REQUEST

Current Zoning: INST(CD) (institutional, conditional) and N1-A (neighborhood 1-A)
Proposed Zoning: NC(CD) (neighborhood center, conditional)

Approximately 4.62 acres located at the northeast intersection of Harwood Lane and Mt. Holly-Huntersville Road, west of Country Lane.

The petition proposes to allow a 12,000 square foot childcare center or medical office and 20,000 square feet of nonresidential uses. A portion of the site is entitled for a childcare center and is currently developed with a single-family dwelling.

RZ-1.0

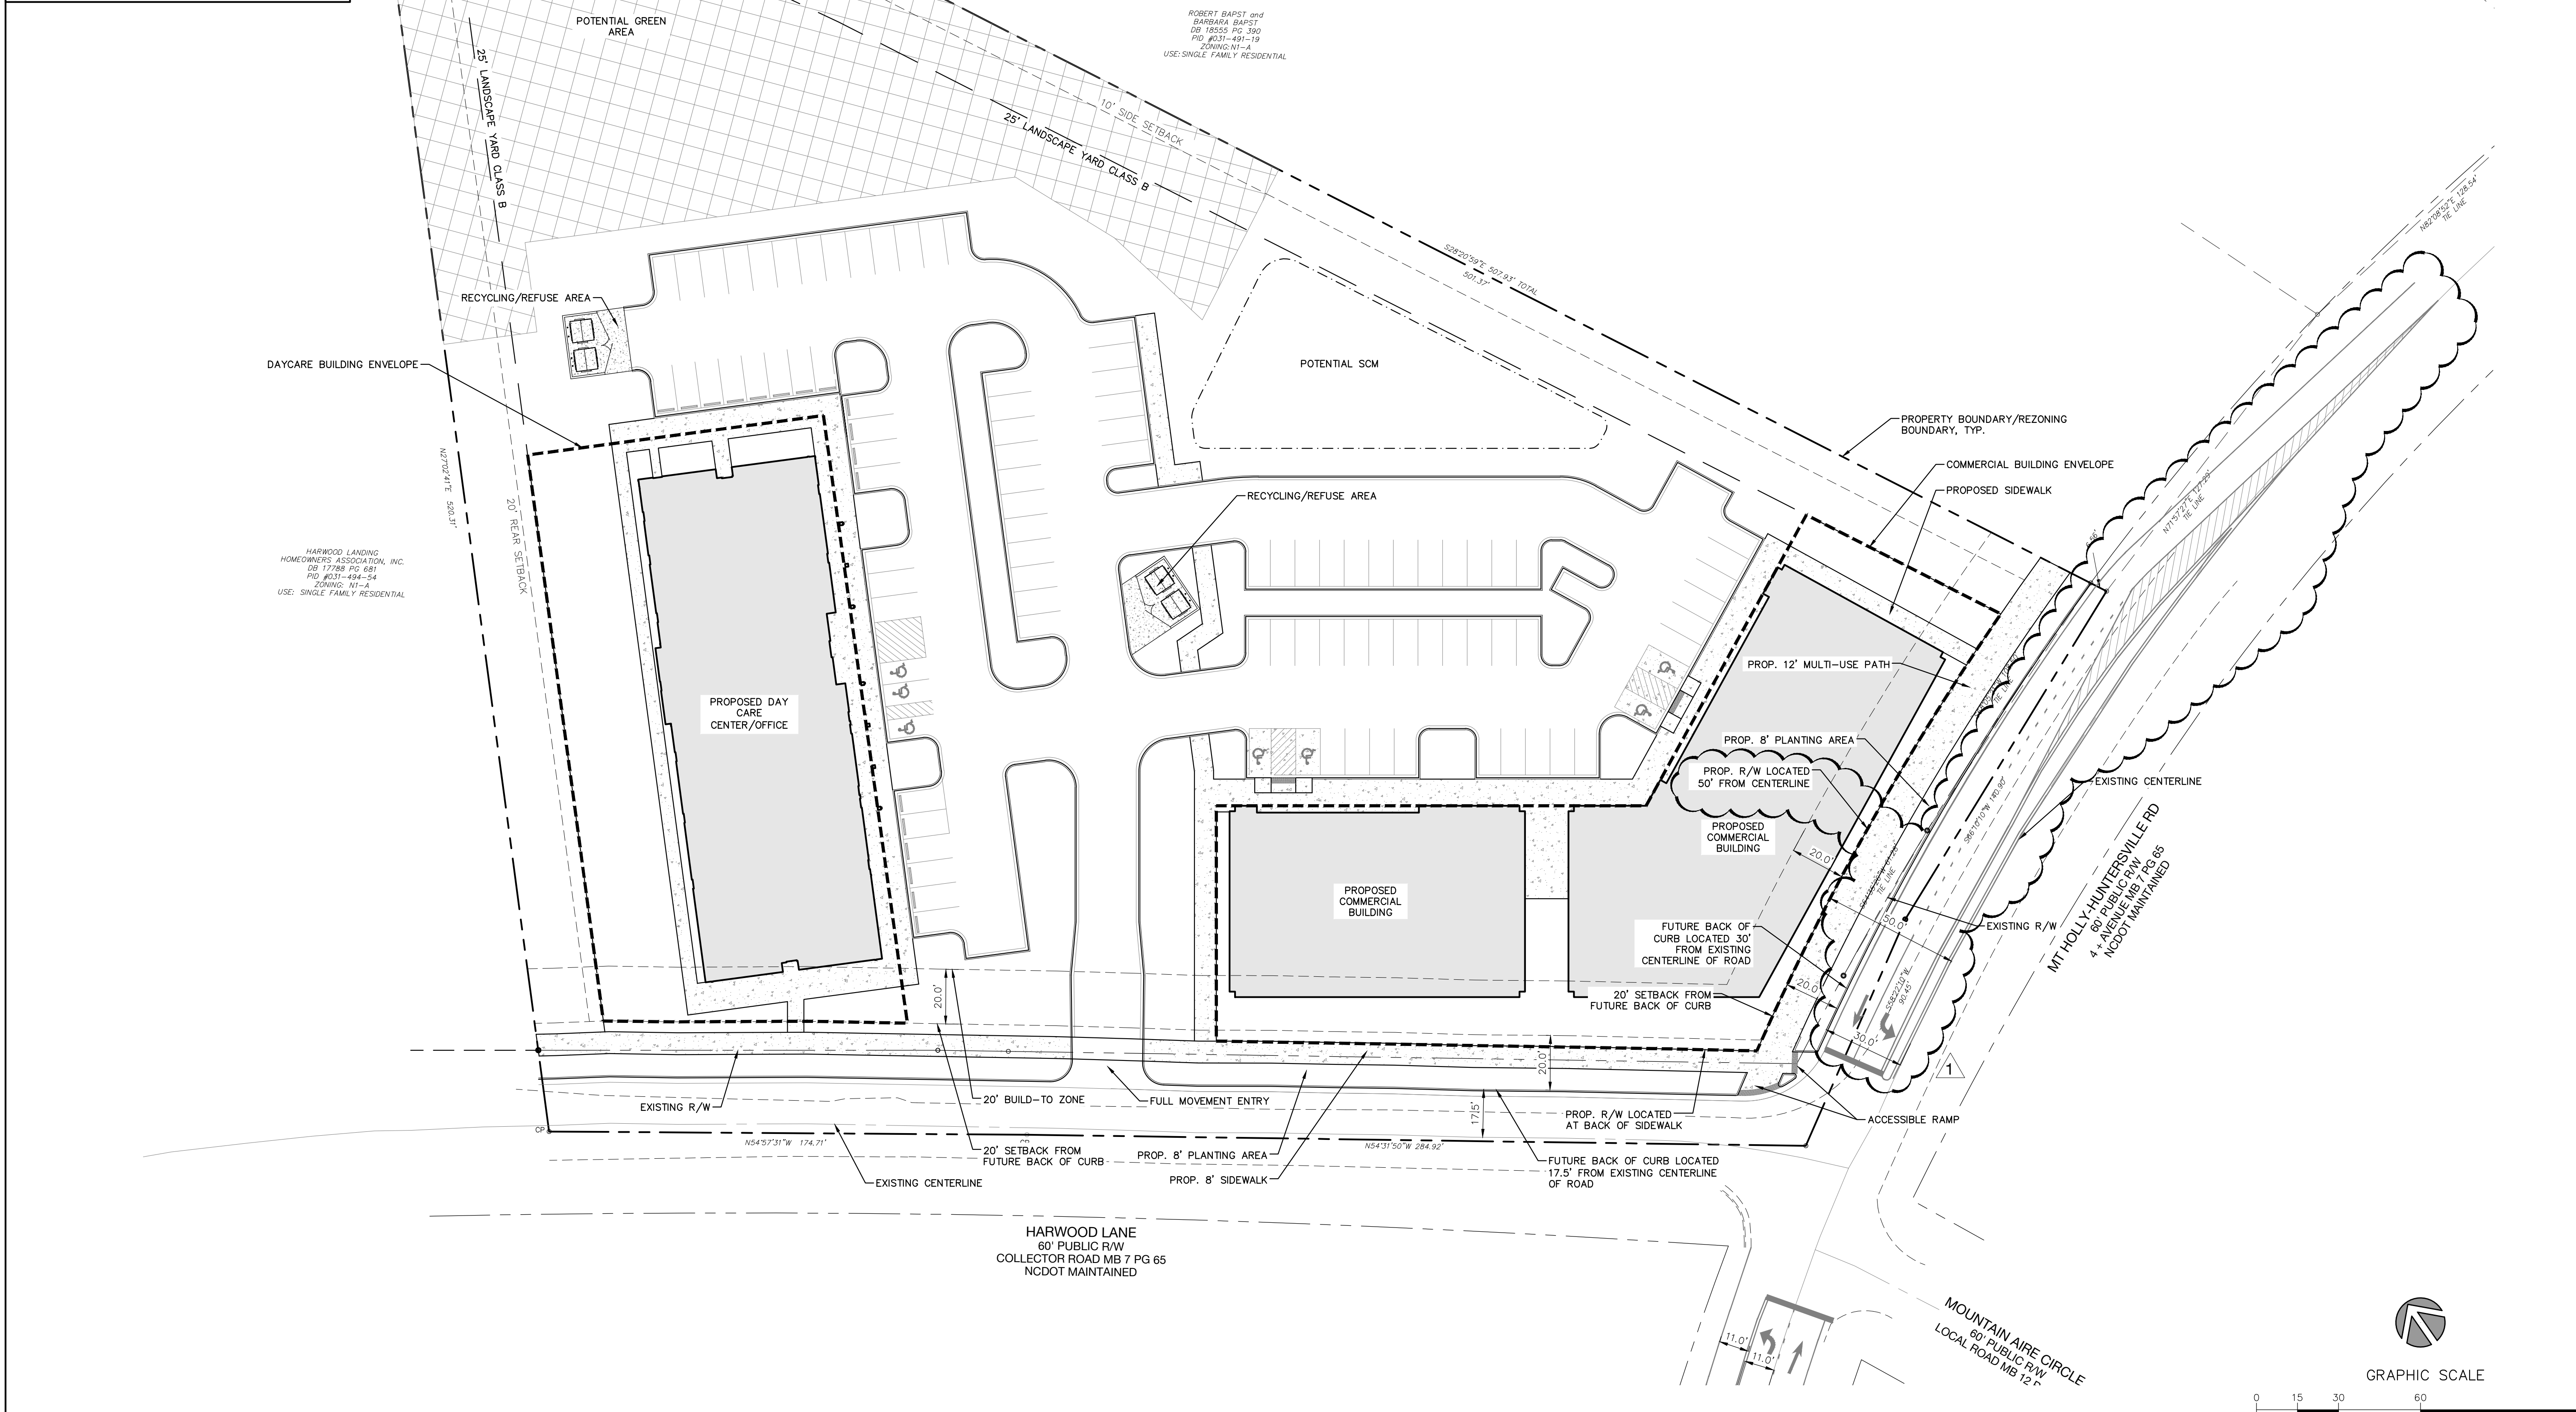
2. ~~Urban Forestry: Green area shown does not meet standards. A large section of what is being shown a protected tree canopy does not have any trees.~~ **ADDRESSED**
3. ~~Tree Survey for Conditional Zoning Map Amendment. A tree survey shall be required for all conditional zoning map amendments.~~ **ADDRESSED**
